RE: Planning Application No: 3/2023/0003 Grid Ref: 373310 436273

Proposal: Advertisement consent for two digital LCD display screen, one on each side of the Street Hub unit.

Proposal: Proposed installation of a BT Street Hub and associated display of advertisement to both sides of the unit.

Further to your request for consultation on the above applications, Whalley Parish Council objects to **BOTH** applications for the following reasons:

DRAWING TITLE
**BT STREETHUB
CLT-205**

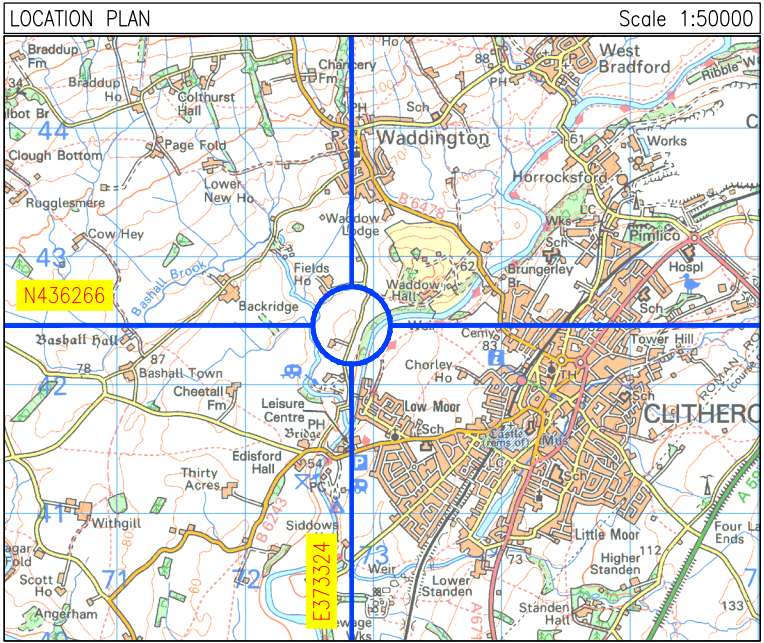
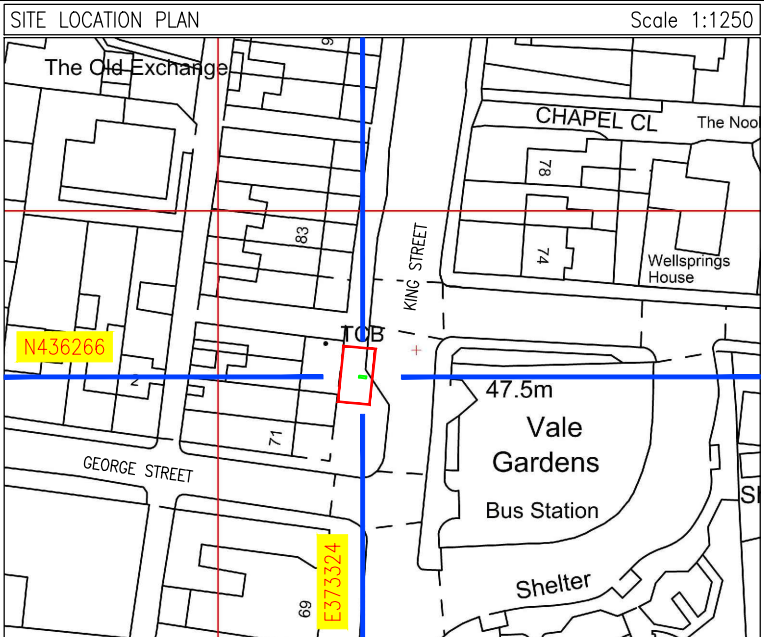
The proposed hub location is too large, incongruous to the area and not a feature of the streetscape in keeping with a conservation area.

From a highways, pedestrian and vehicle safety perspective the unit in its illuminated nature is distracting to drivers, and its location is potentially dangerous as its proximity to the highway obstructs drivers sightline to the nearby zebra crossing, bus stop and private vehicle access way.
